July 30, 2019

**RE: Good Hope Hospital  
Erwin, NC – Harnett County**

Plans relative to the above-named project have been reviewed for general compliance with the 2018 North Carolina Building Code with the following comments:

1 LIFE SAFETY PLAN
SCALE: 1/8"=1'-0"

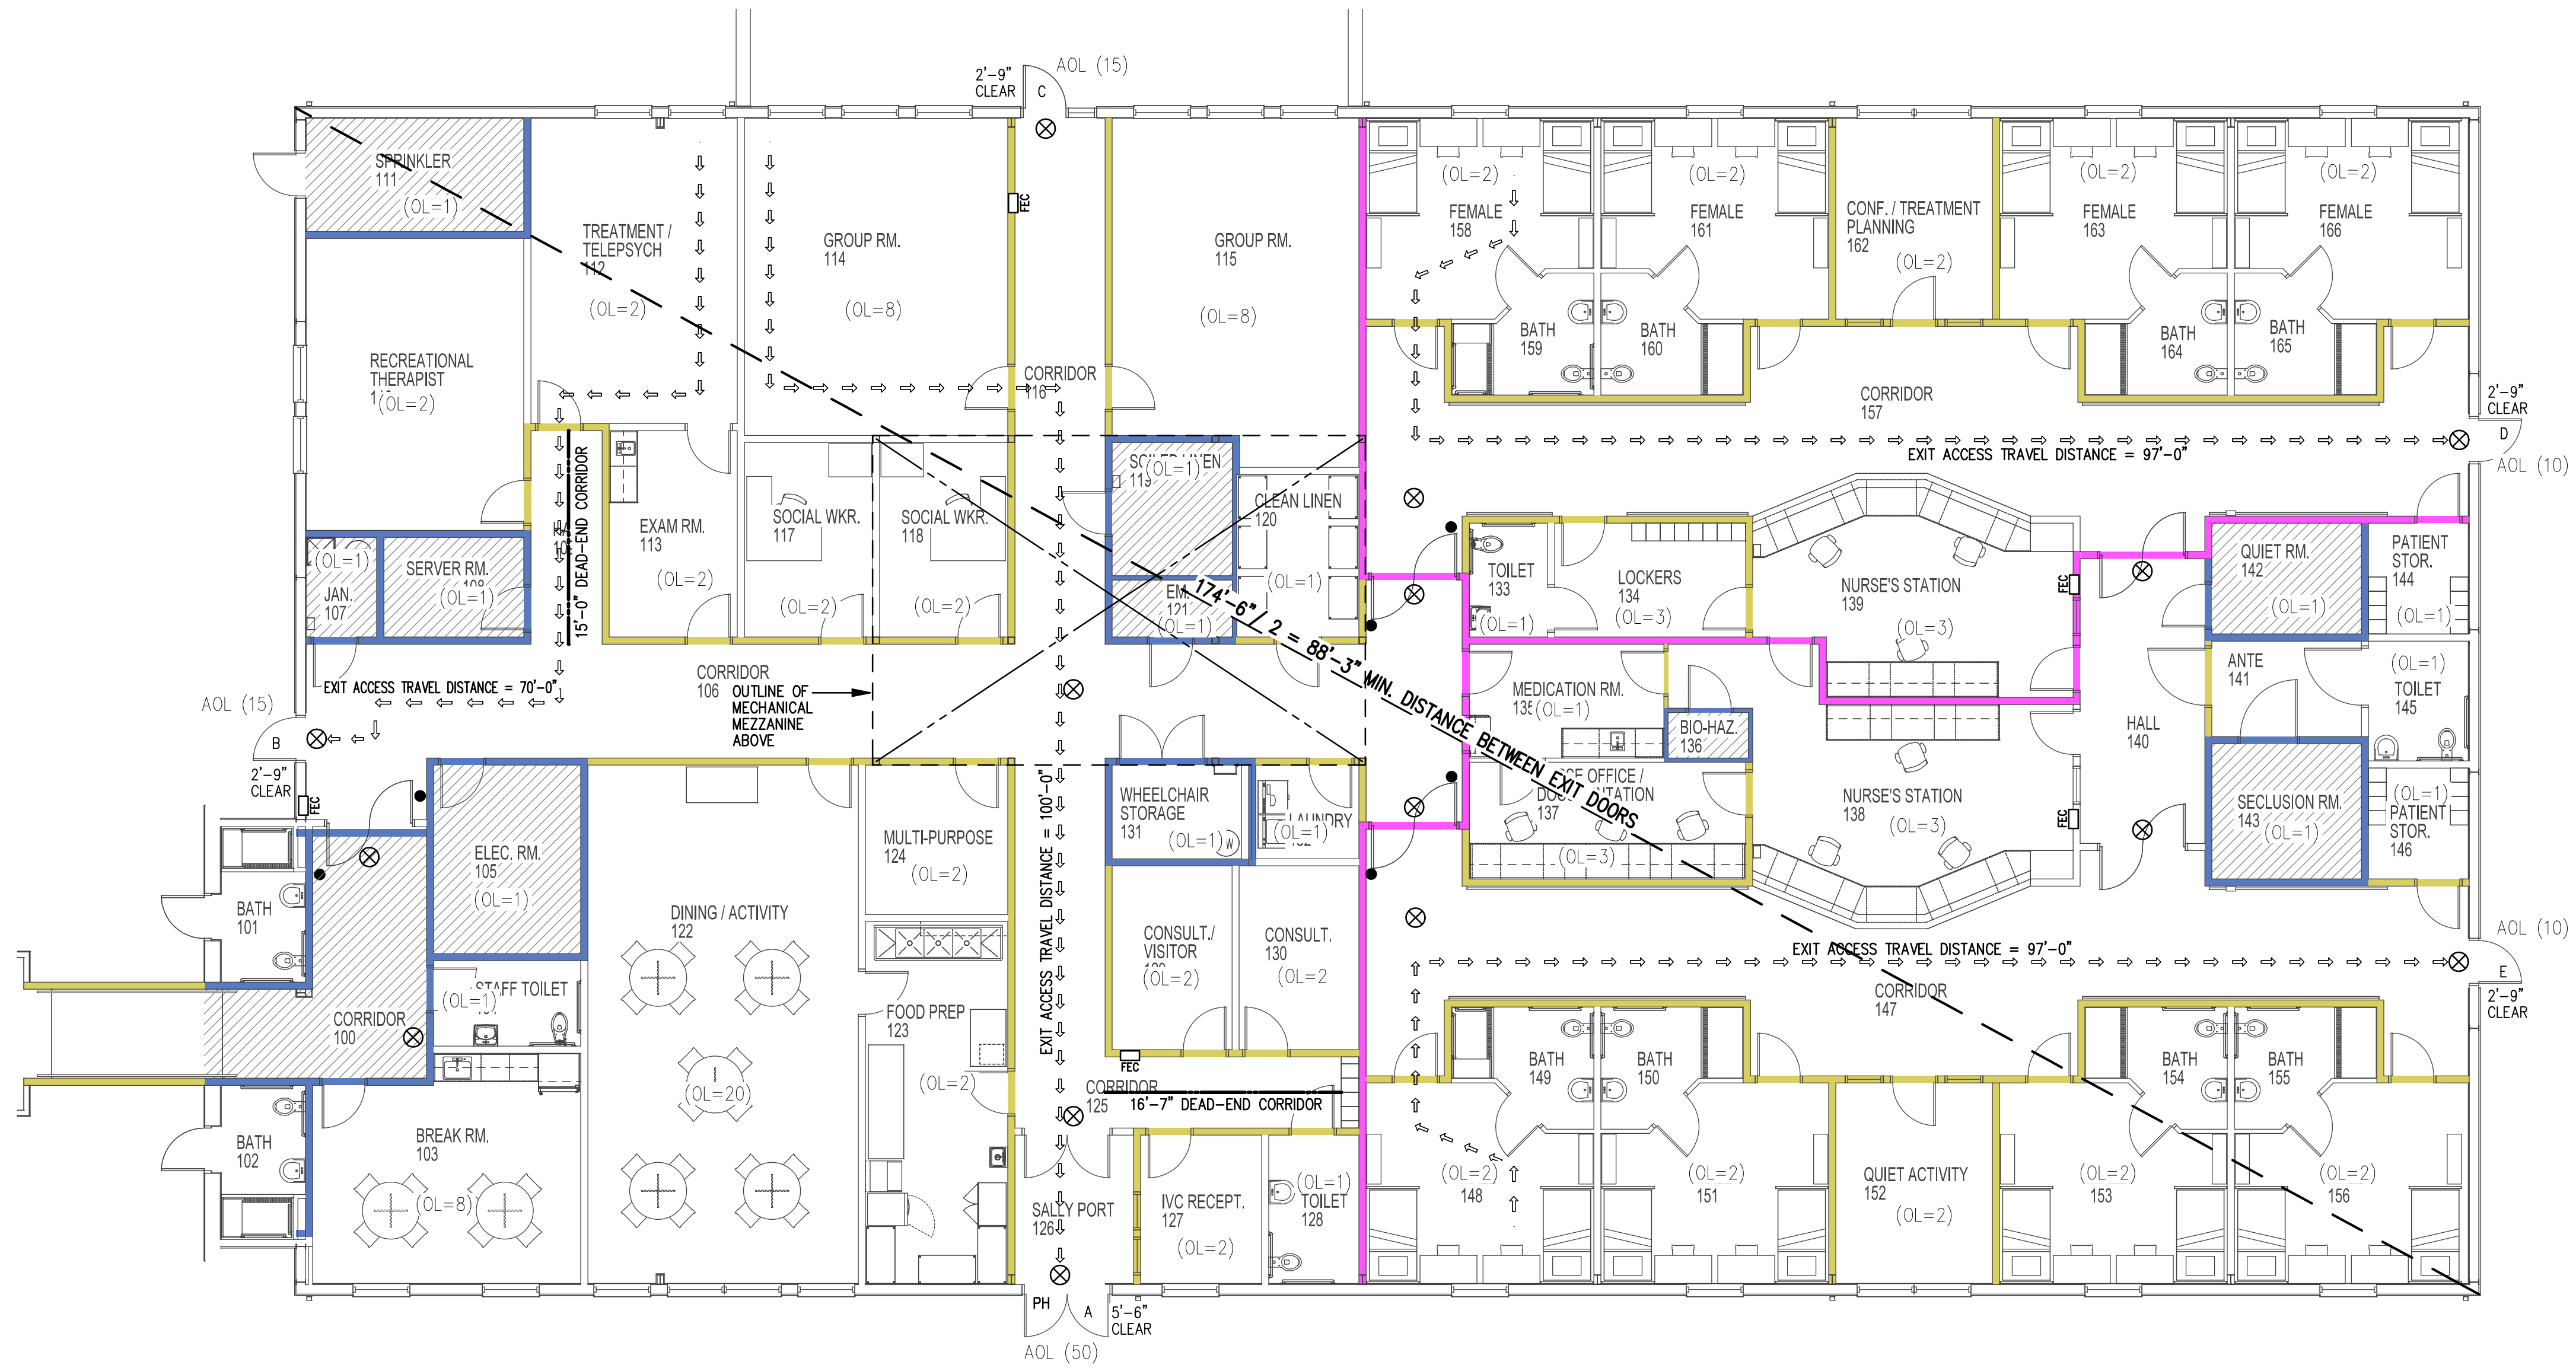
24. Provide the actual occupant load for the existing doors that open into the outdoor court between the new building and the existing building. Show on sheet G1.4.

25. Verify with the local fire code official that all portions of the building can be accessed from the fire apparatus access road.
26. Show the total actual occupant load of the addition and number of required exists on sheet G1.4.
